EN010129 – THE SLOUGH MULTIFUEL EXTENSION PROJECT

APPLICATION FOR DEVELOPMENT CONSENT UNDER SECTION 37 ‘APPLICATIONS FOR ORDERS GRANTING DEVELOPMENT CONSENT’ OF THE PLANNING ACT 2008 FOR THE EXTENSION OF THE CONSENTED SLOUGH MULTIFUEL FACILITY AND ASSOCIATED DEVELOPMENT

LAND AT EDINBURGH AVENUE, THE SLOUGH TRADING ESTATE, SLOUGH, SL1 4TU

I write on behalf of the Applicant to respond to the following points of clarification raised by the Secretary of State for Energy Security & Net Zero in the letter dated 6th October 2023:

Figure 1: Phase 1 Habitat Map

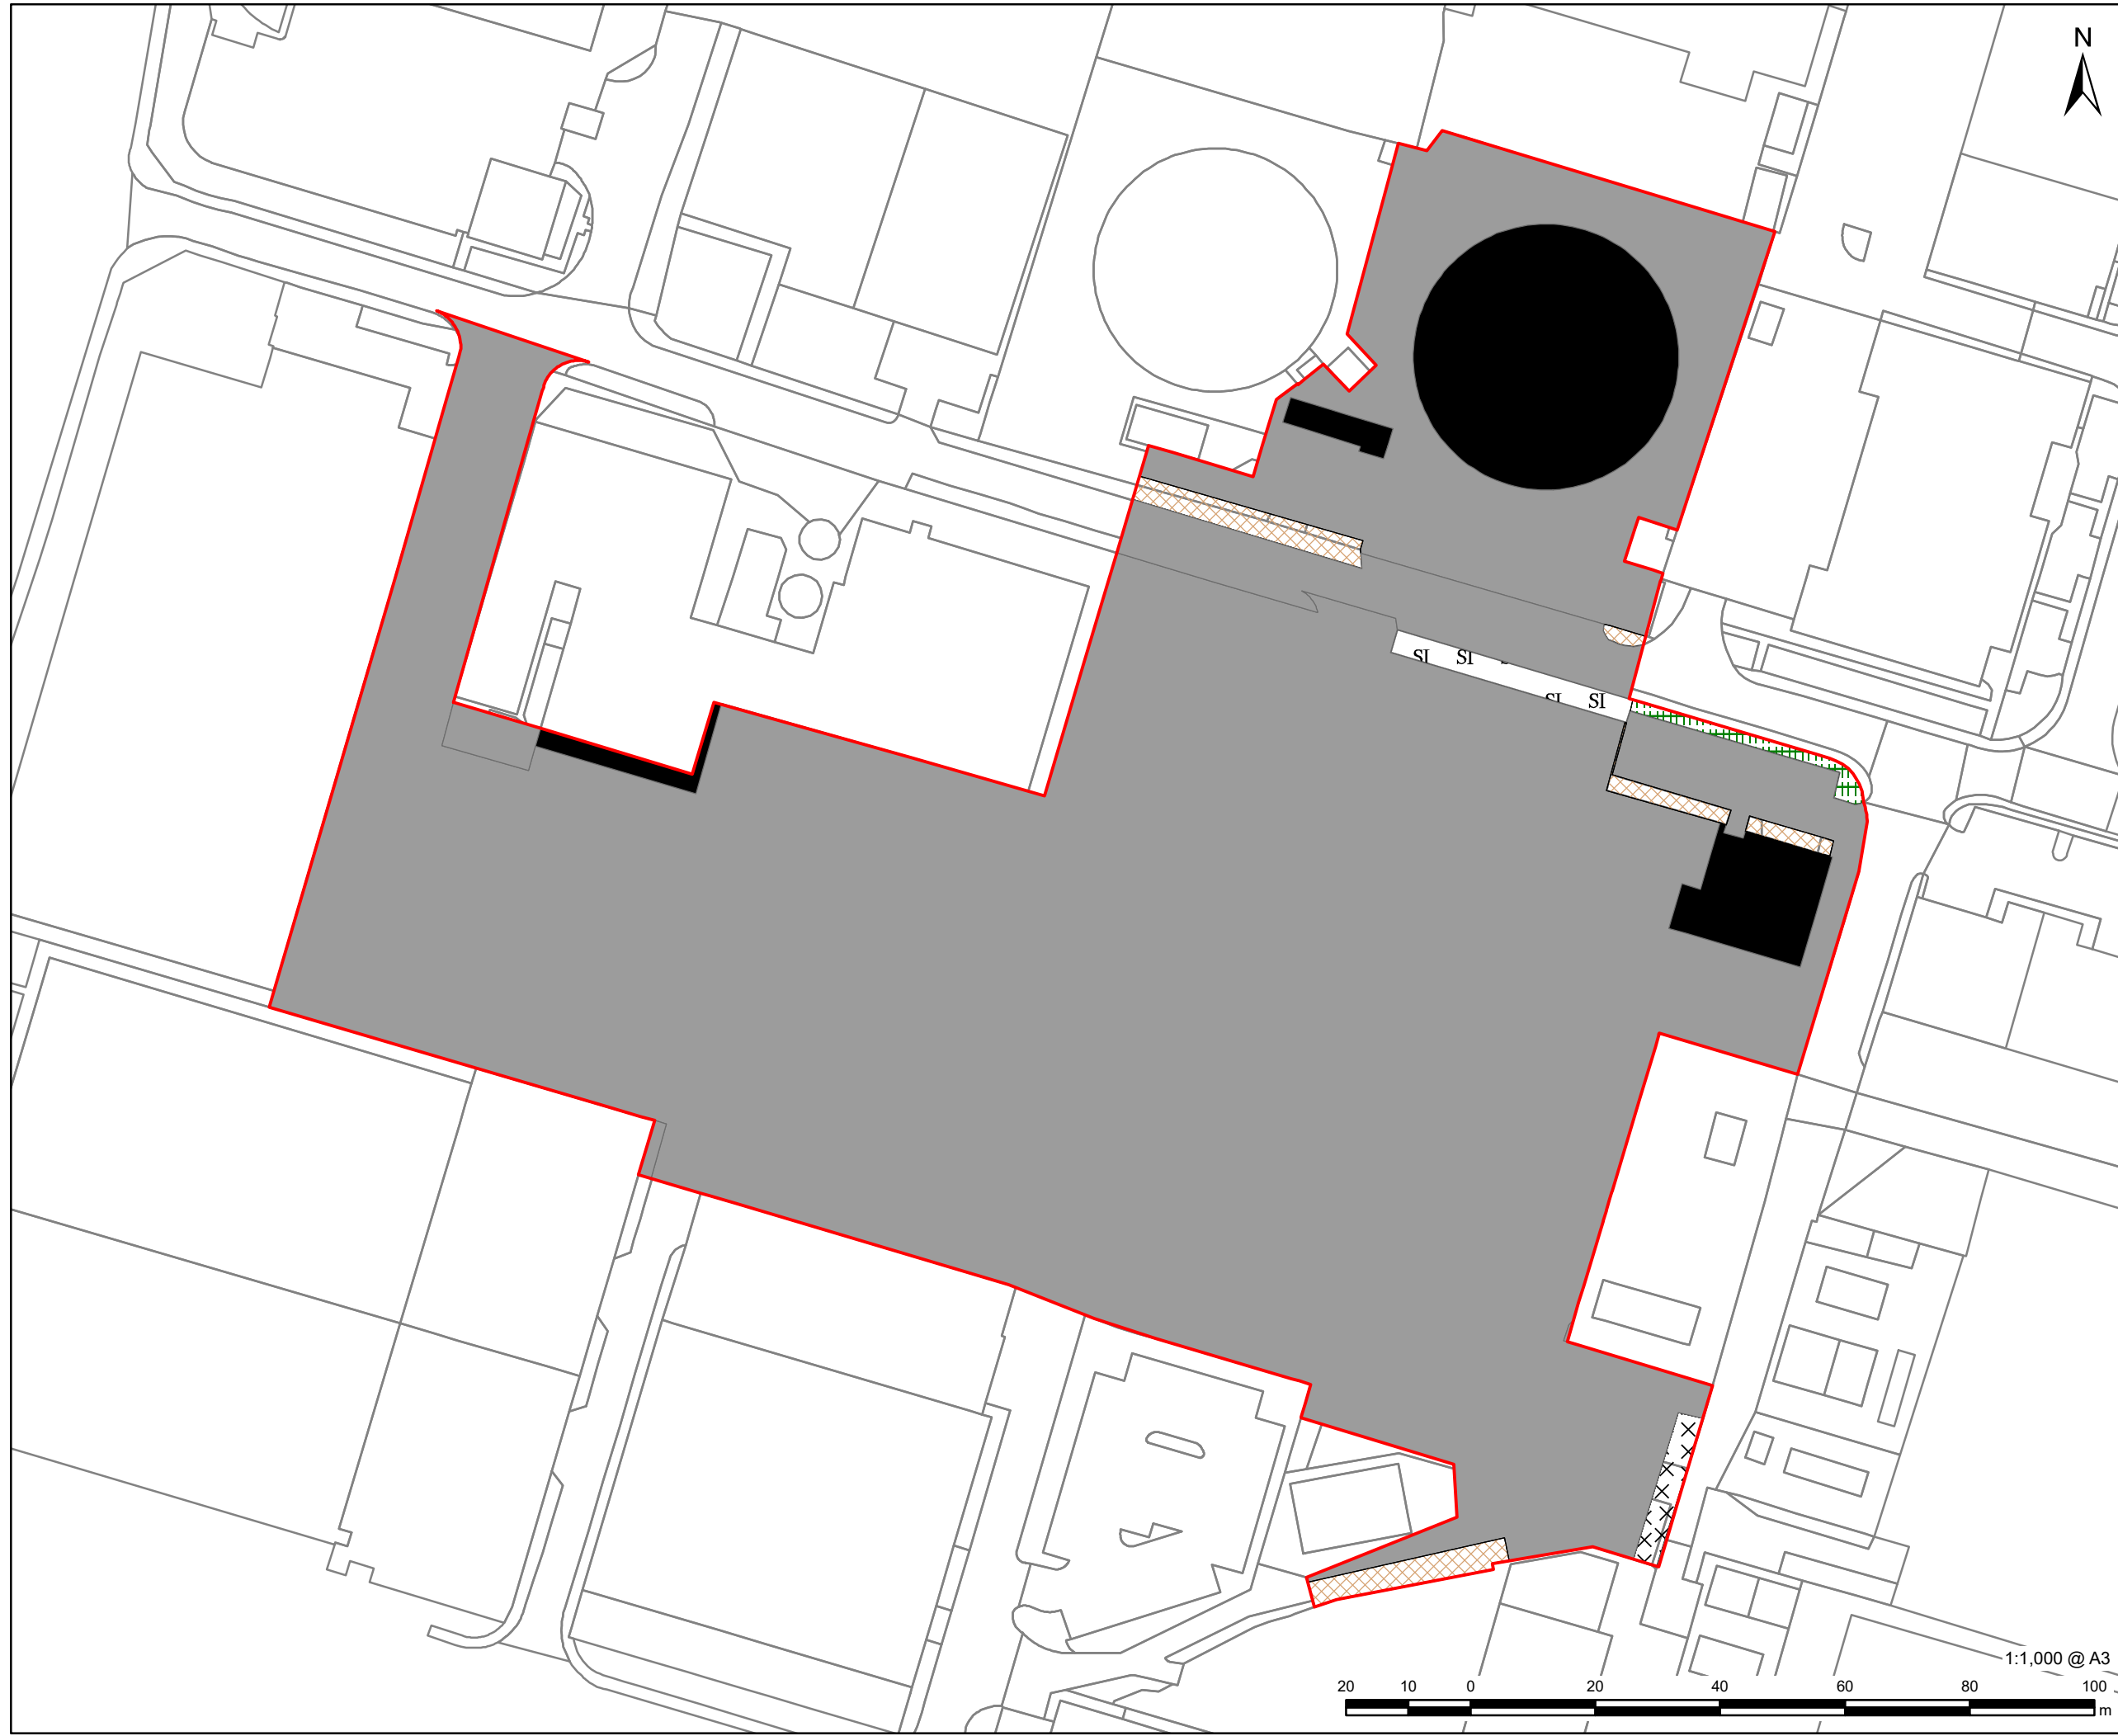
The Secretary of State notes that the Environmental Statement [APP-035] (10.8.17) concludes that there would be no effect from the Proposed Project on the spread of Invasive Non-Native Species ('INNS'), partly on the basis of biosecurity measures being secured and employed. In response to the Examining Authority's First Written Questions (ExQ1), the Applicant stated [REP2-020] that biosecurity measures are addressed in the existing Construction Environmental Management Plan ('CEMP') to prevent the spread of INNS. However, the Secretary of State can see no reference to INNS or relevant biosecurity measures in the existing CEMP [APP-062]. The Secretary of State notes that biosecurity measures are specified in your supporting Environmental Statement (10.8.15 - 10.8.17). The Applicant is invited to clarify how biosecurity measures to prevent the spread of INNS will be secured as part of the Proposed Project, and to include any updated documents as required.

As the Secretary of State correctly notes, there are no relevant biosecurity measures in the existing CEMP [APP-062]. The cross-reference in the Applicant's response to the Examining Authority's First Written Questions (ExQ1) [REP2-020] to biosecurity measures being included in the CEMP is an error.

The remainder of the Applicant's response [REP2-020] is correct, however, in that the INNS will not be disturbed as part of the Proposed Project, as confirmed in the Environmental Statement [APP-035] (10.8.14). The INNS has been identified in some small patches, which are not located near the works that comprise the Proposed Project. The Proposed Project is therefore not expected to result in any disturbance of or engagement with INNS.

To assist the Secretary of State, the Applicant's environmental consultant has marked up Figure 10.3 [APP-056] to indicate the areas where wall cotoneaster is located. The marked up plan has been appended to this letter.

As noted by the Secretary of State, the Environmental Statement [APP-035] (10.8.15 - 10.8.17) recommends biosecurity measures to prevent the spread of INNS. The Applicant has discussed the position with the environmental consultant who prepared the Environmental Statement, and they have confirmed that due to lack of any connectivity between the INNS and the Proposed Project, the conclusion of “no effect” identified in the Environmental Statement remains correct without the need to secure any biosecurity measures in the CEMP or any other document.

Based on the fact that no disturbance of or engagement with INNS is expected to occur as a result of either the Proposed Project or the Consented Development, and as confirmed by the Applicant’s environmental consultant, the Applicant does not consider that any biosecurity measures are required. However, if the Secretary of State is minded to include biosecurity measures as part of the Order, the Applicant would propose the addition of the following requirement in Schedule 2, Part 1 of the Order:

(1) In the event that works involving the removal or anticipated disturbance of any wall cotoneaster vegetation are required in connection with the construction of any part of the authorised development, works may not commence in respect of the construction of that part of authorised development until a biosecurity strategy detailing measures to prevent the spread of wall cotoneaster during the construction of that part of the authorised development has been submitted to and approved by the relevant planning authority.

(2) Where a biosecurity strategy is agreed pursuant to paragraph (1) above that biosecurity strategy must be implemented as approved.”
